From: Laura Gibbons
Sent: 10 June 2019 12:58
To: Planning.Responses
Subject: RE: Planning Consultation on WA/99/18/DOC

Engineers comments regarding condition 25& 32- surface water drainage scheme

APPLICATION **WA/99/18/DOC**

Description of Works: Application for approval of details reserved by conditions imposed on planning reference WA/44/17/OUT relating to conditions 5, 9, 10, 11, 12 13, 16, 17, 24, 25, 27, 28, 30, 32, 33, 36, 41 and 43

TYPICAL CELLULAR SOAKAWAY DETAIL
(1:20)

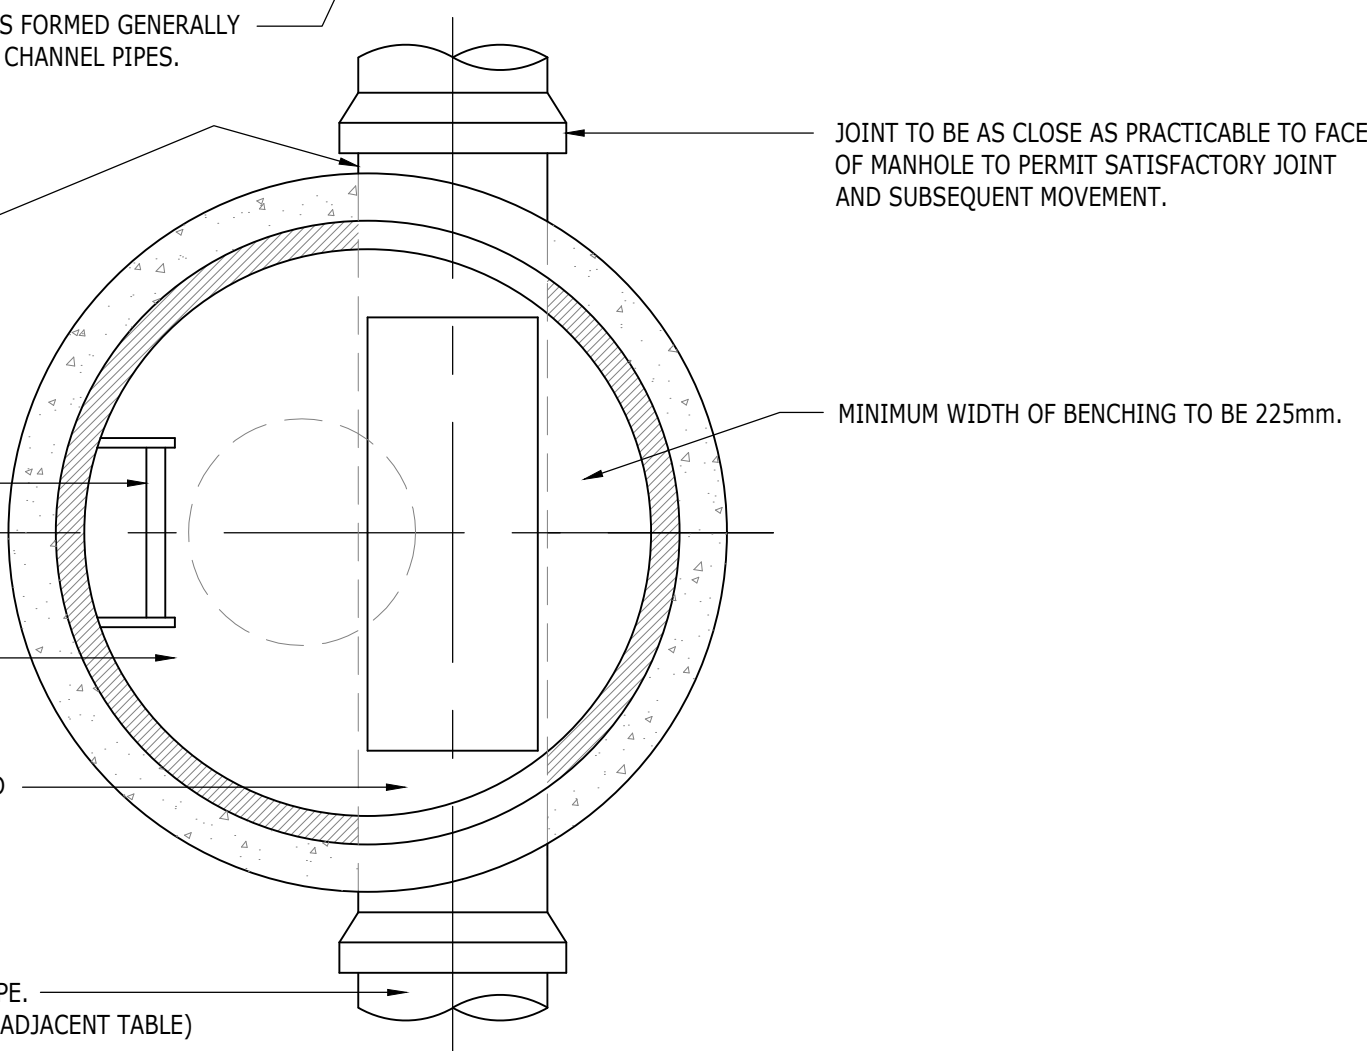
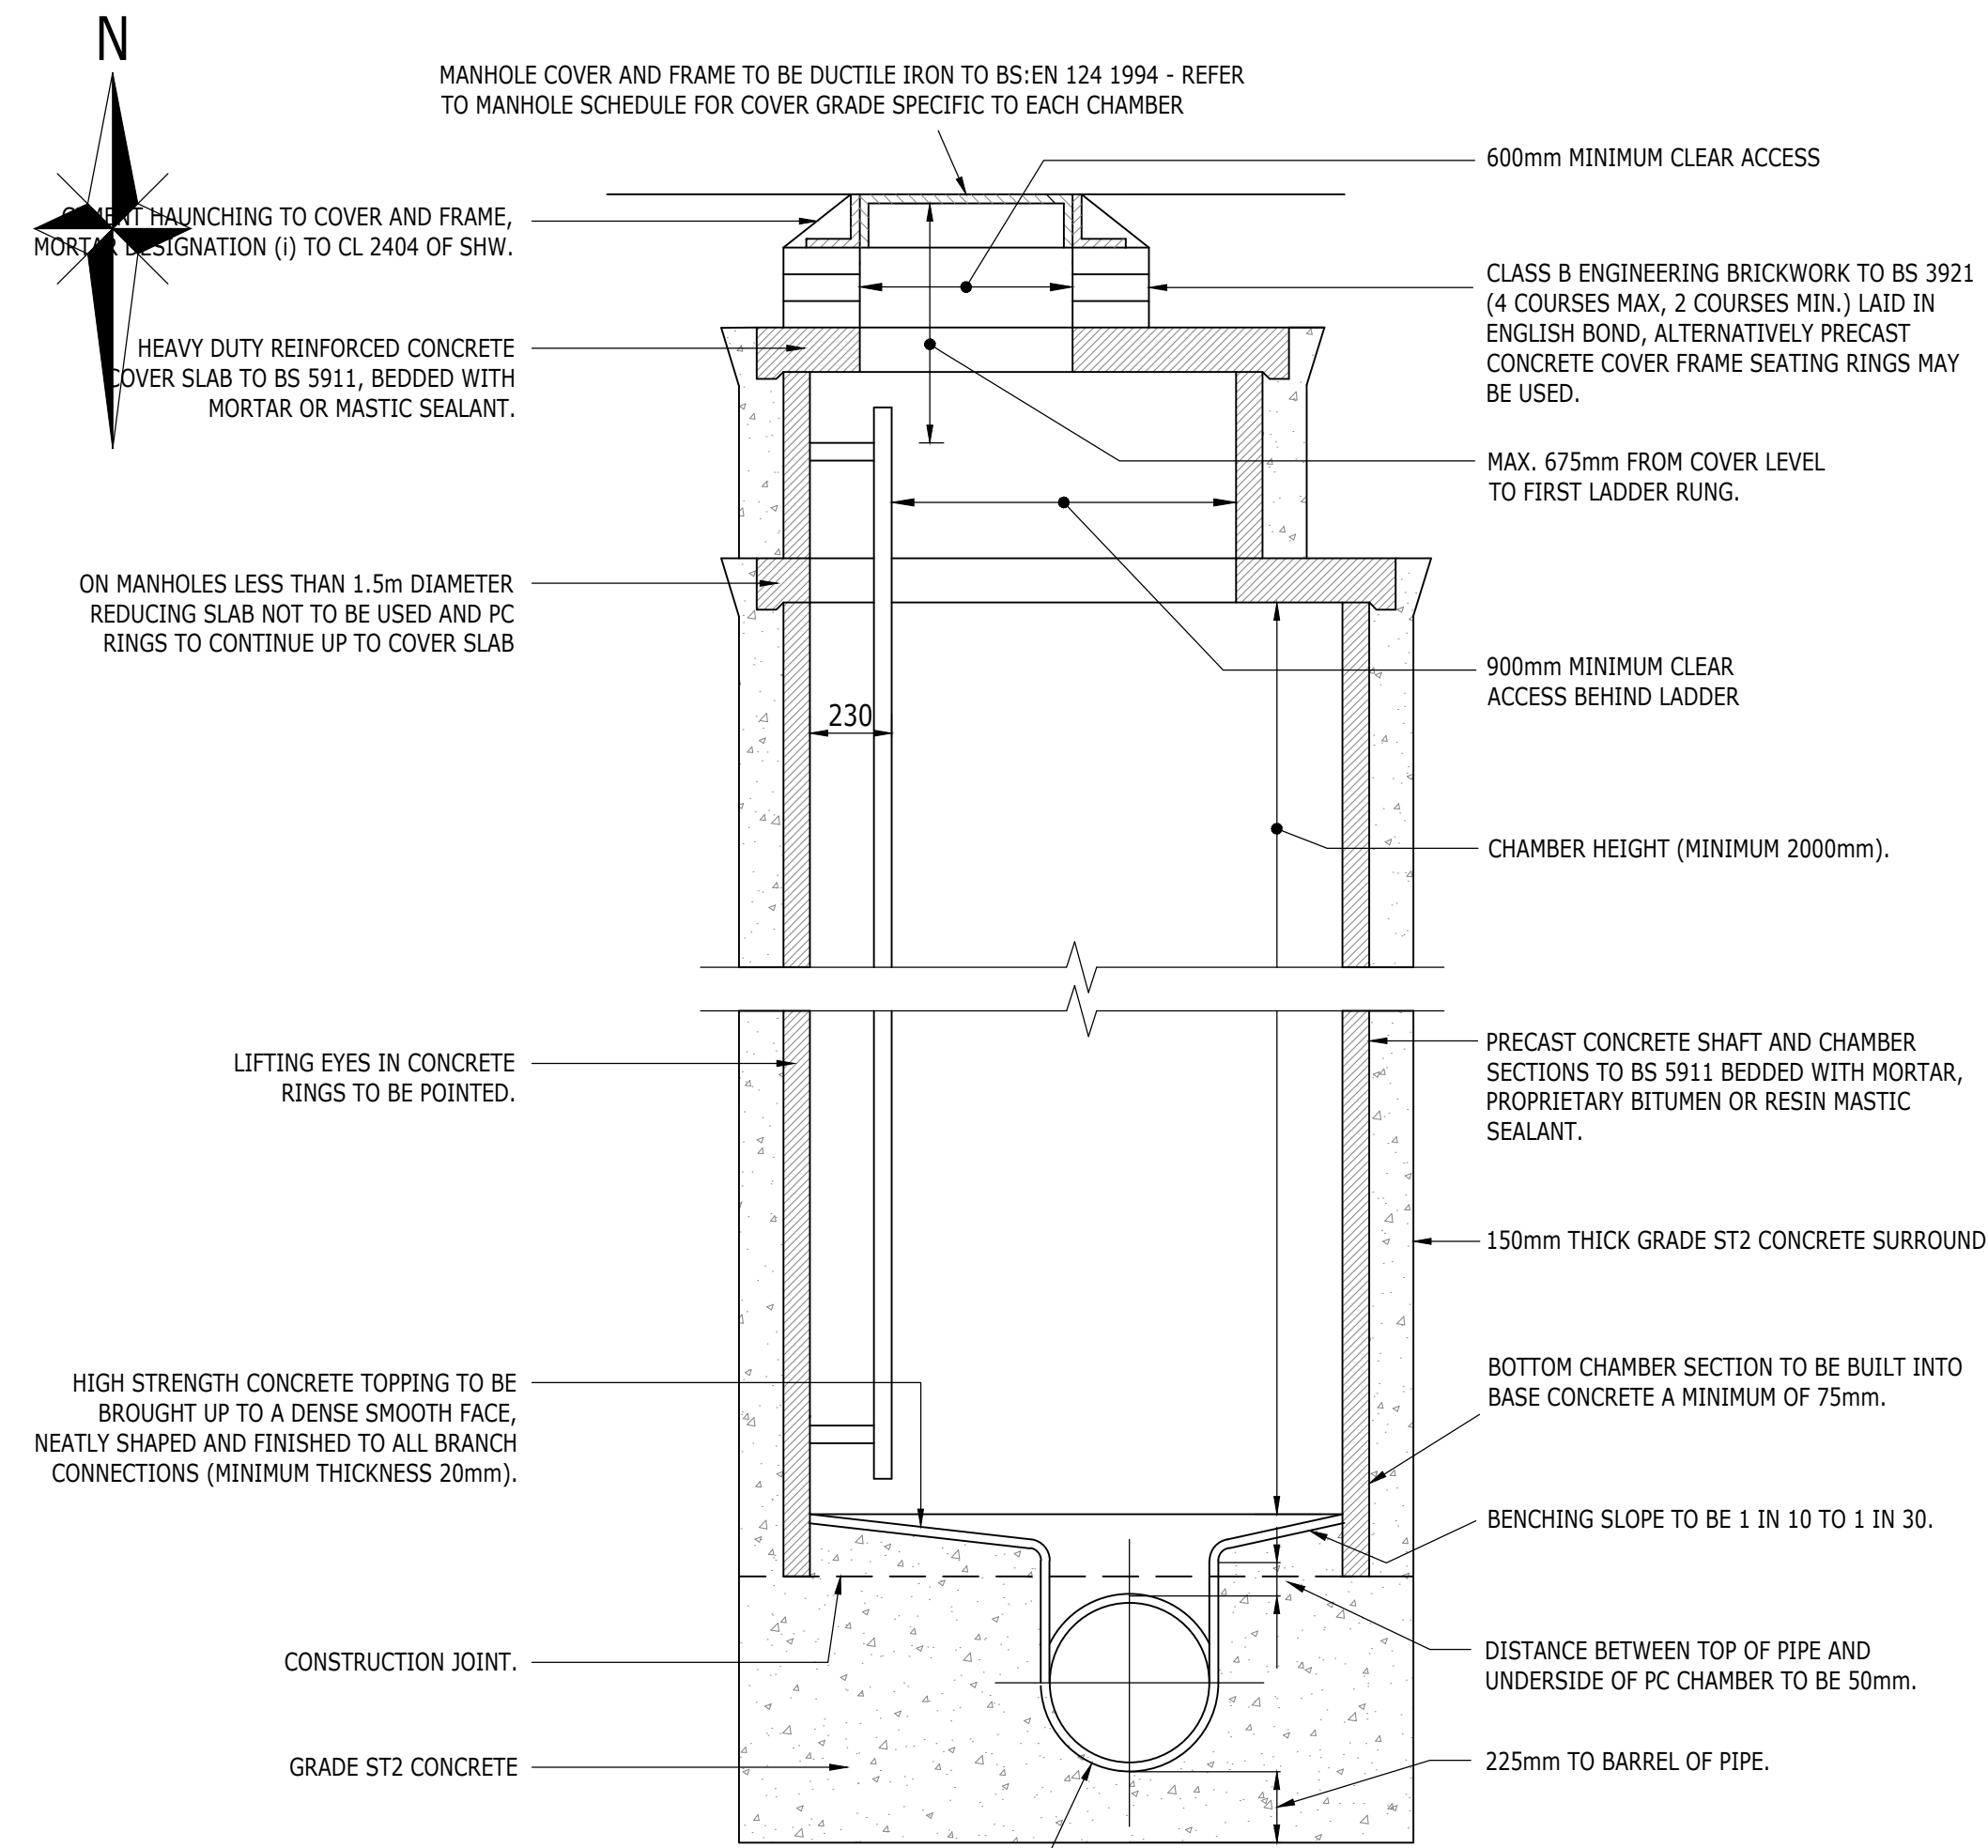
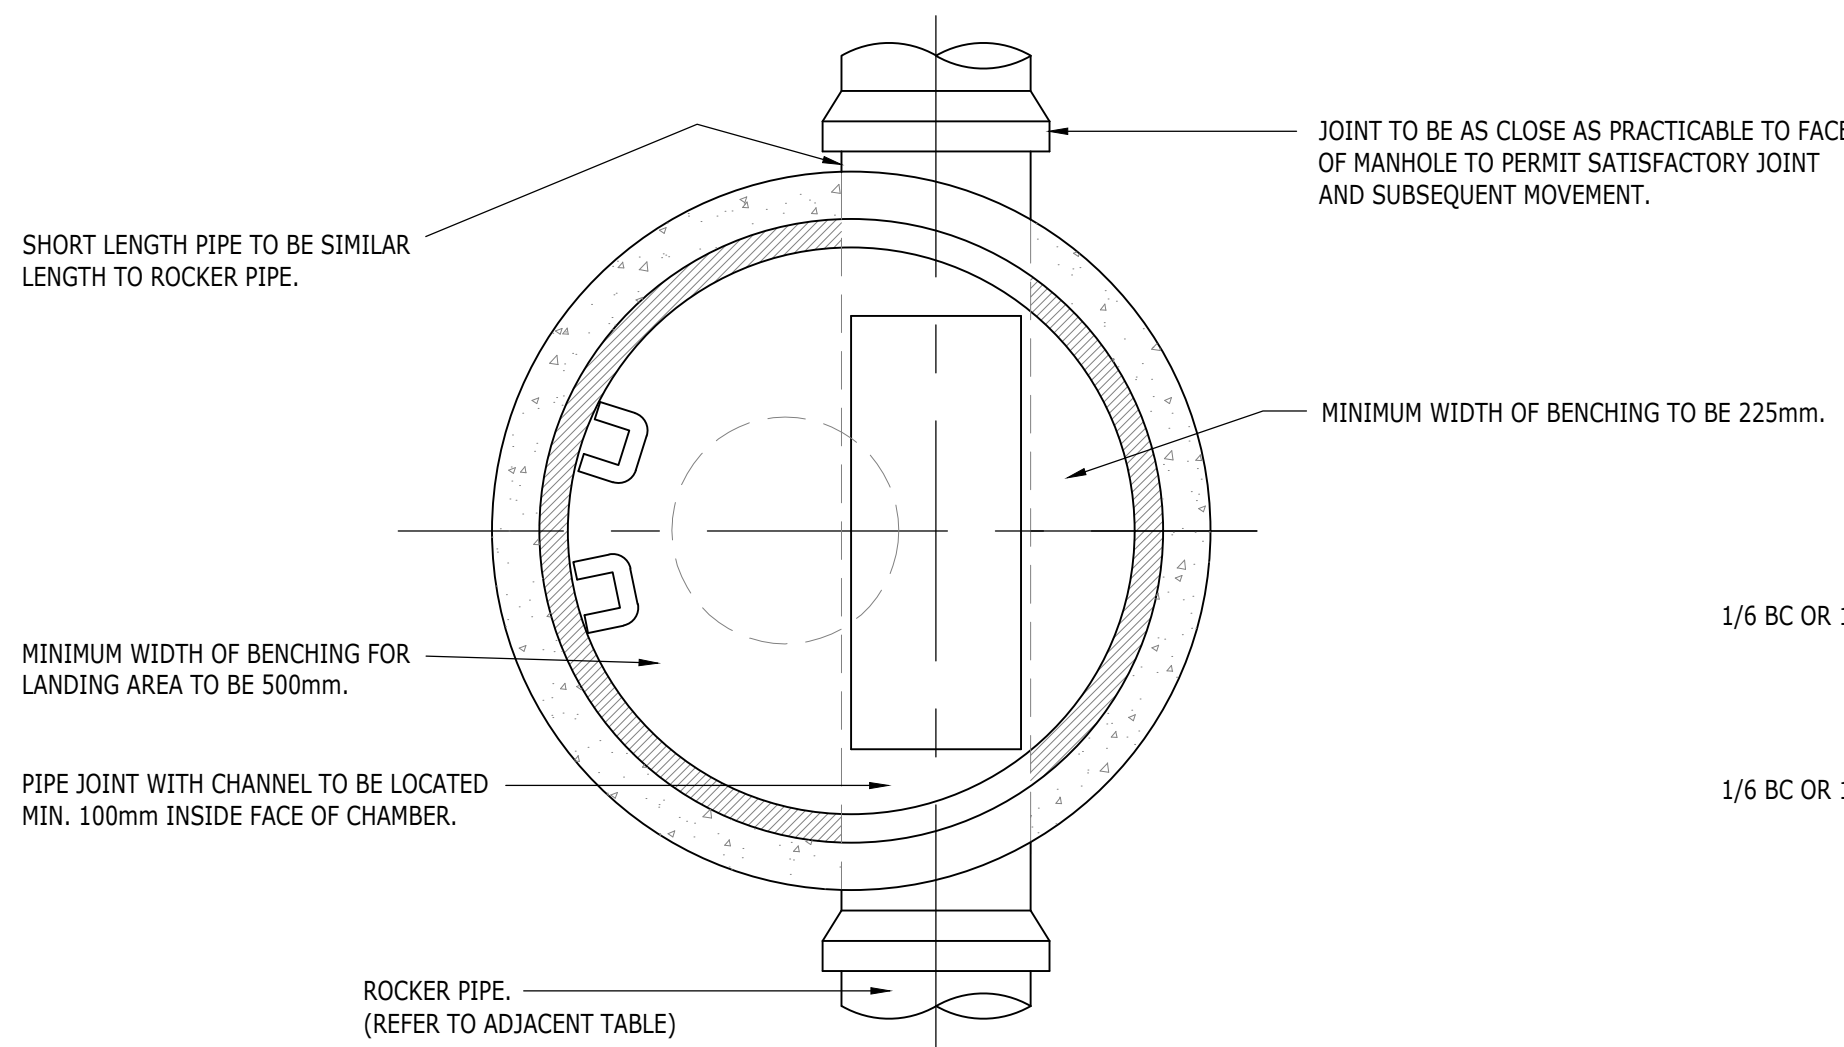
An updated maintenance manual needs to be provided that includes permeable paving, and removes features such as hydrobrakes that are not being proposed for the site.
